**SITE 43/44, SYDNEY OLYMPIC PARK
 DESIGN EXCELLENCE COMPETITION
 JURY REPORT – 23/08/10**

Executive Summary

scale	1 : 1000	drawing no.	DA-1A-3000
drawn	DH	issue	B
checked	AT	project no.	090086

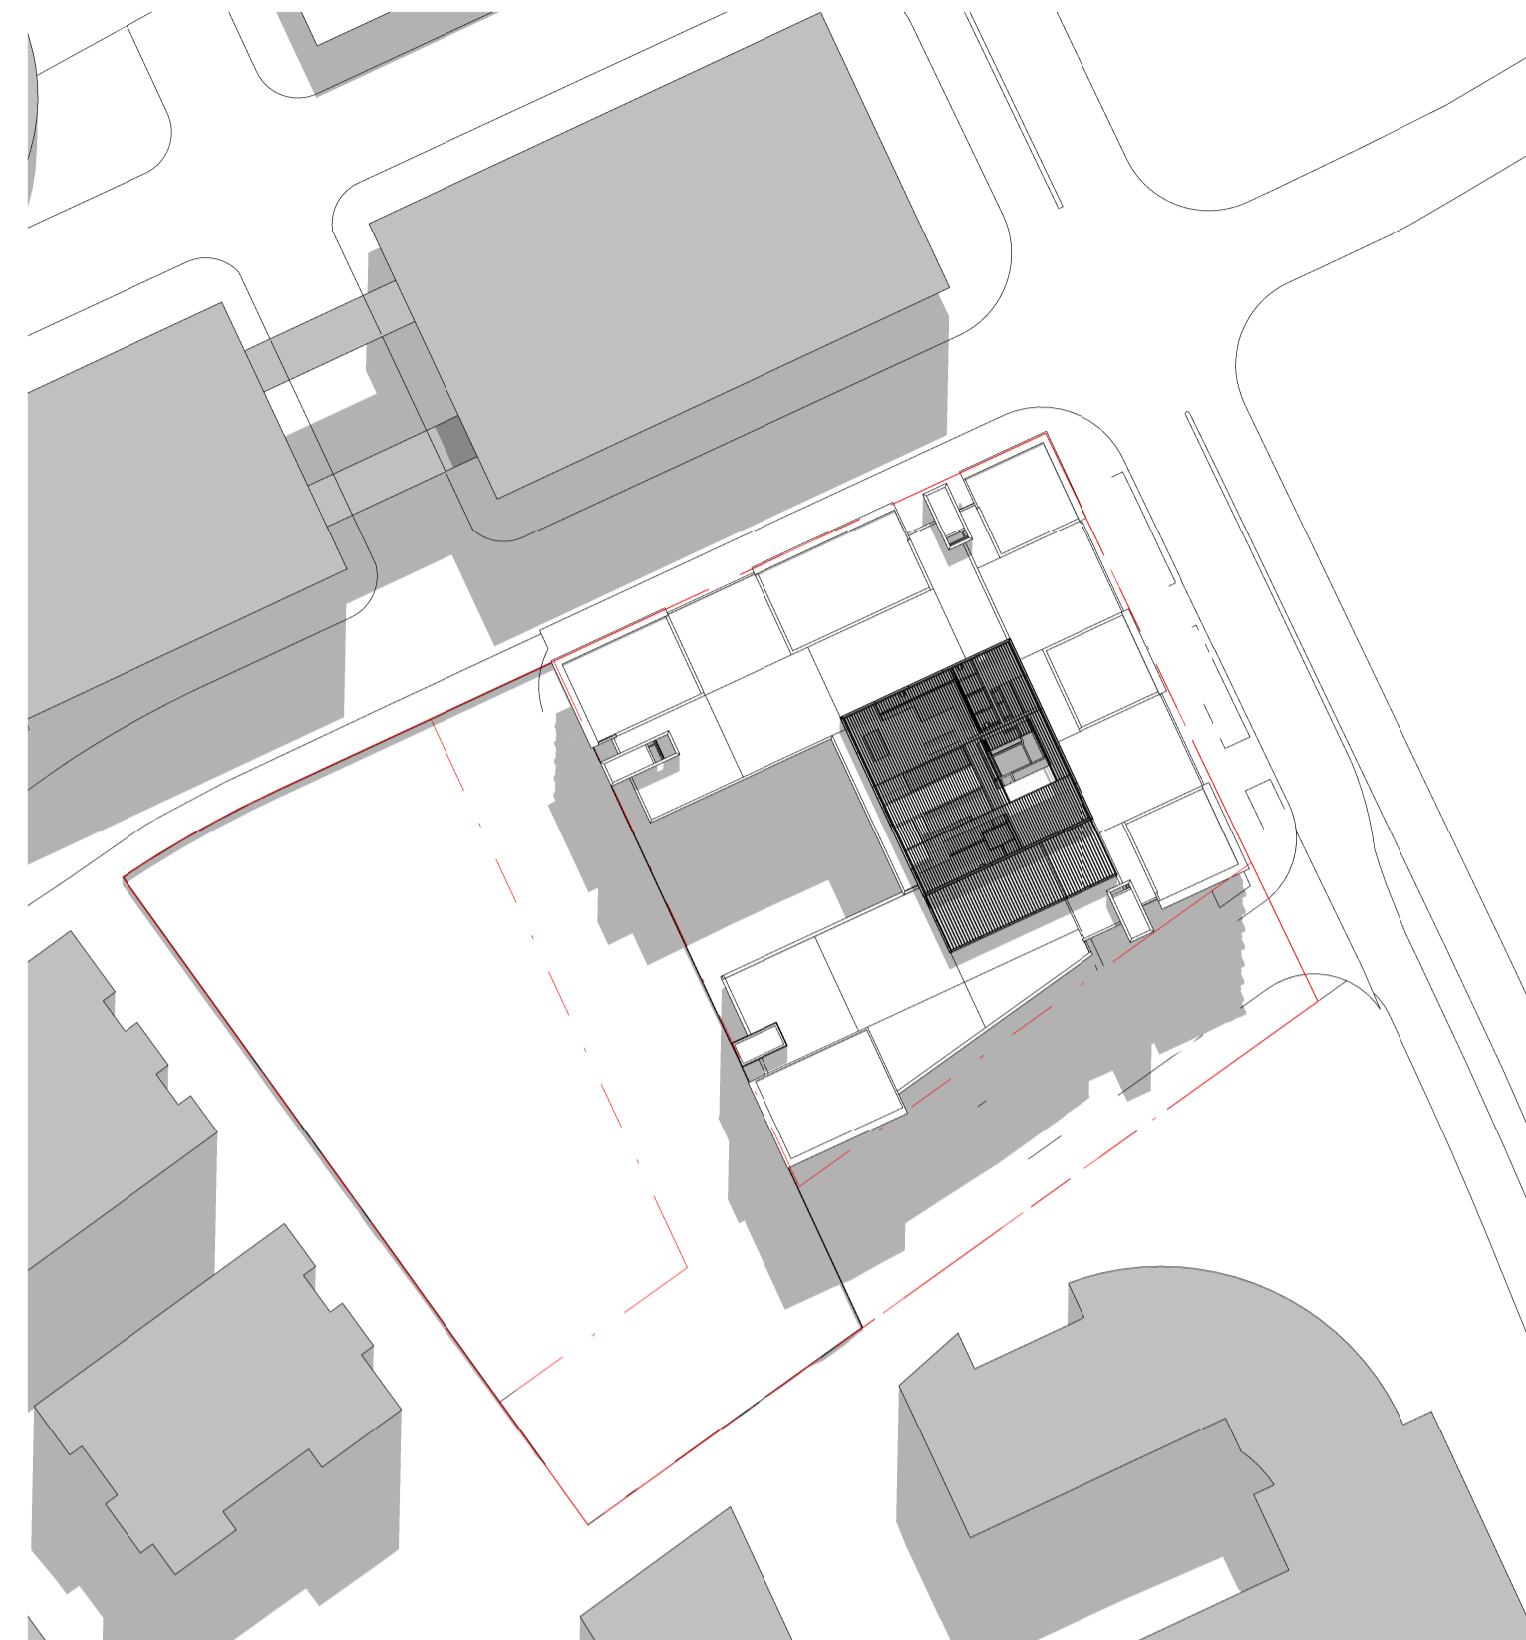
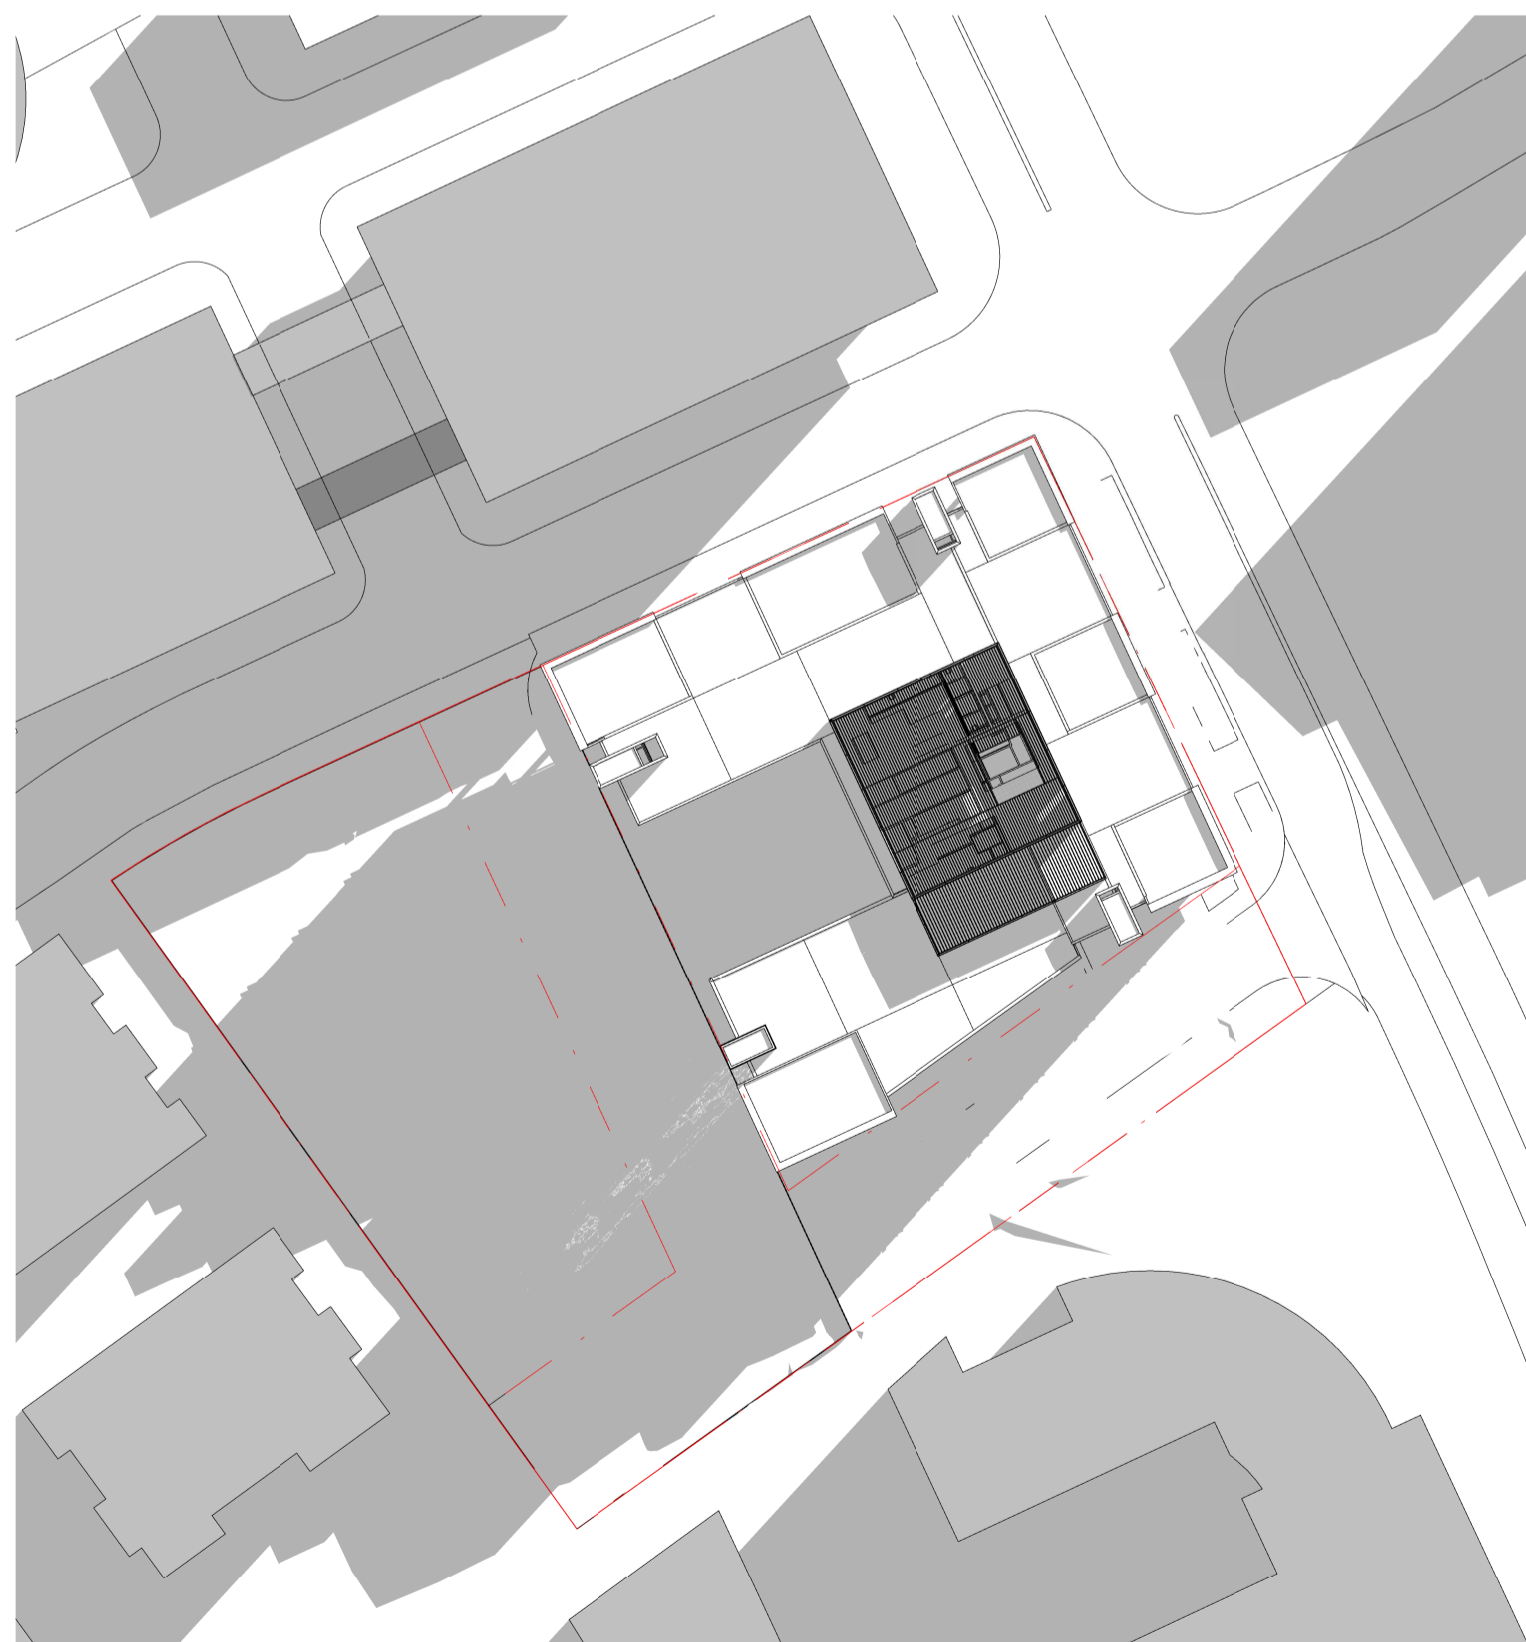
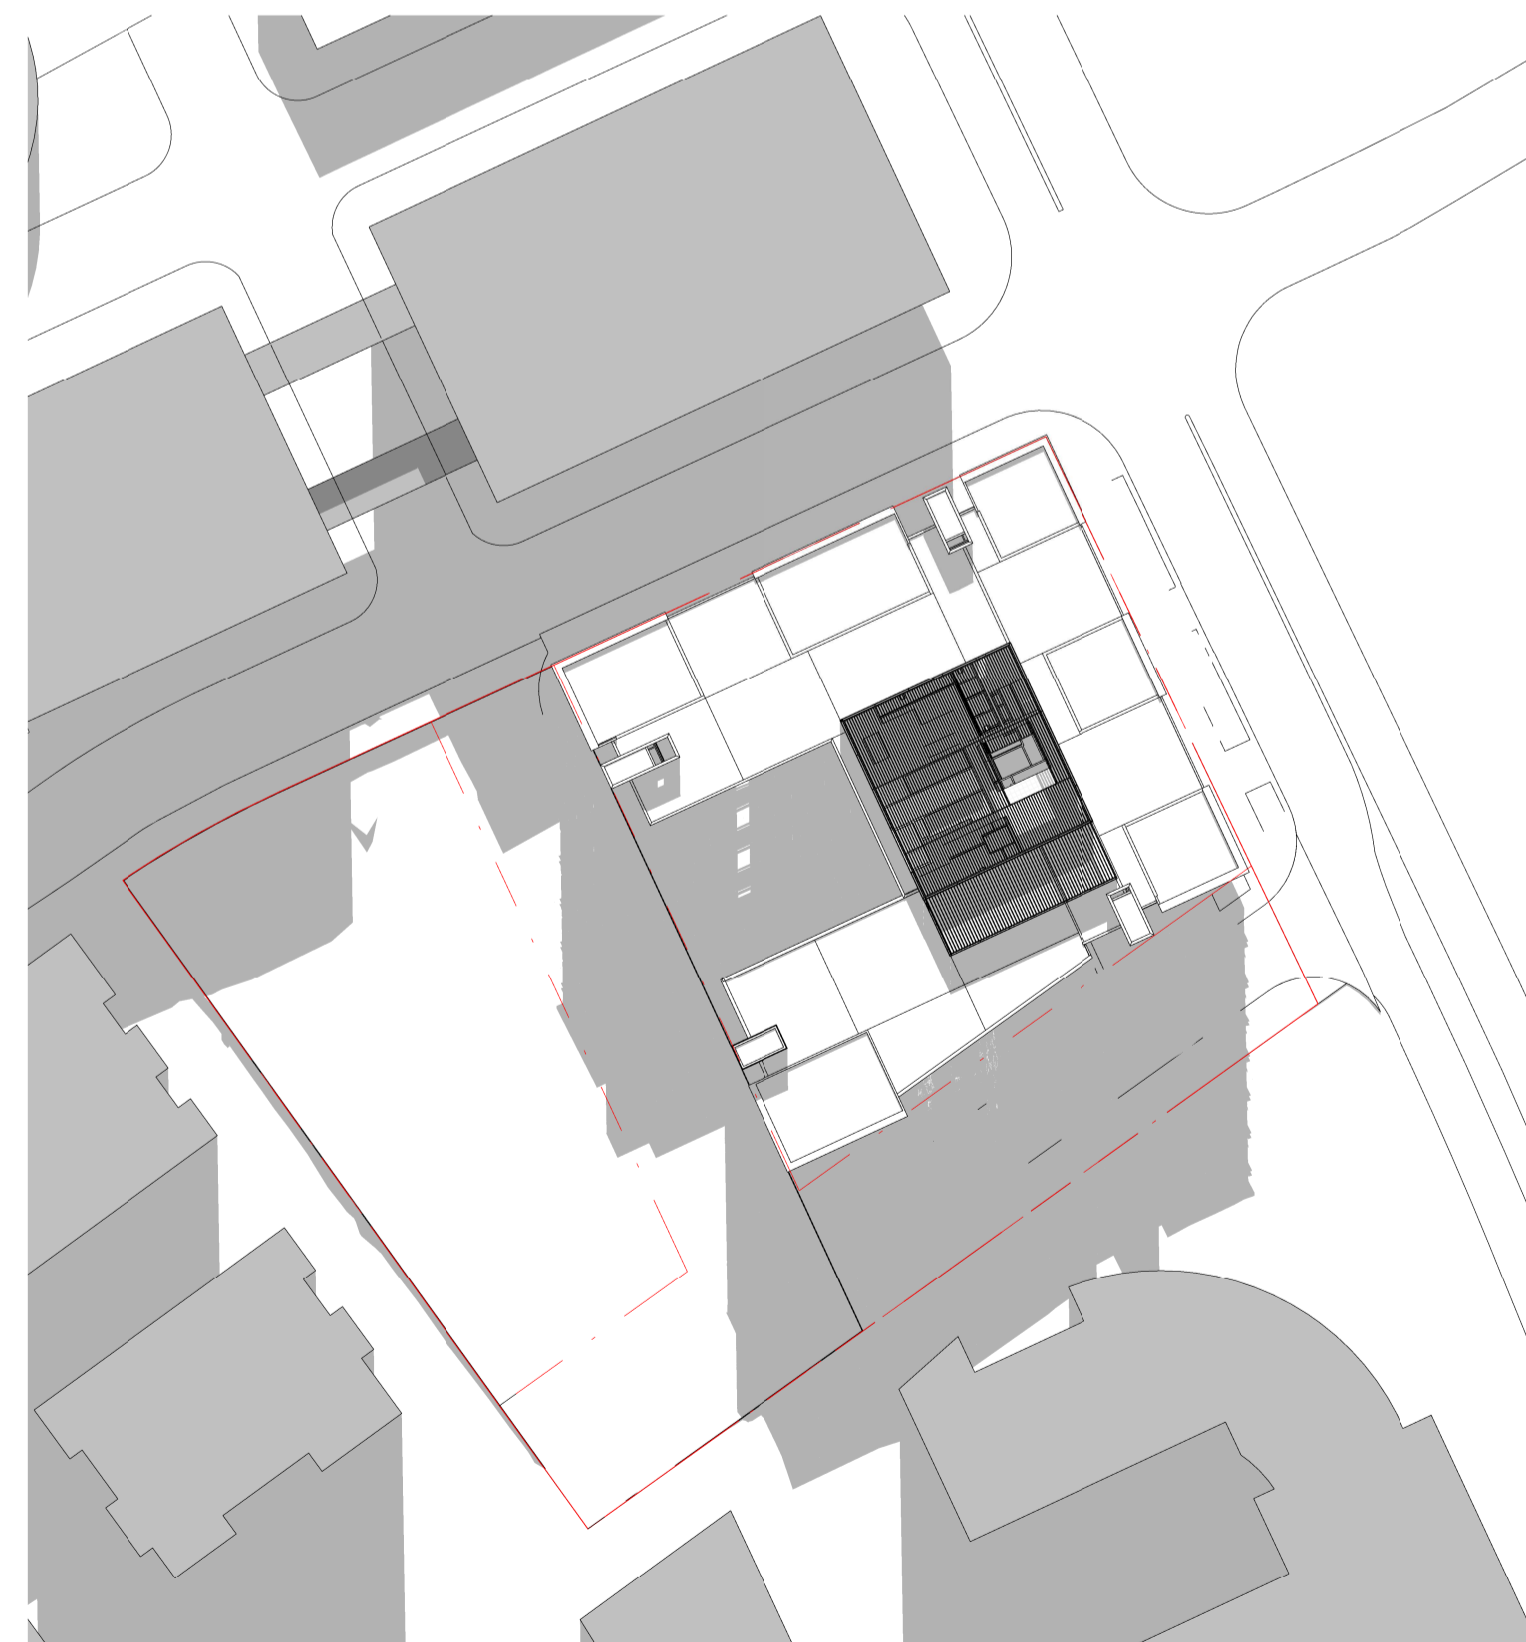
- The proposed loading zone for the supermarket noting that the cost and area occupied. This requires further consideration.
- Overshadowing of the courtyard will also need to be reviewed due to the orientation of the surrounding buildings.
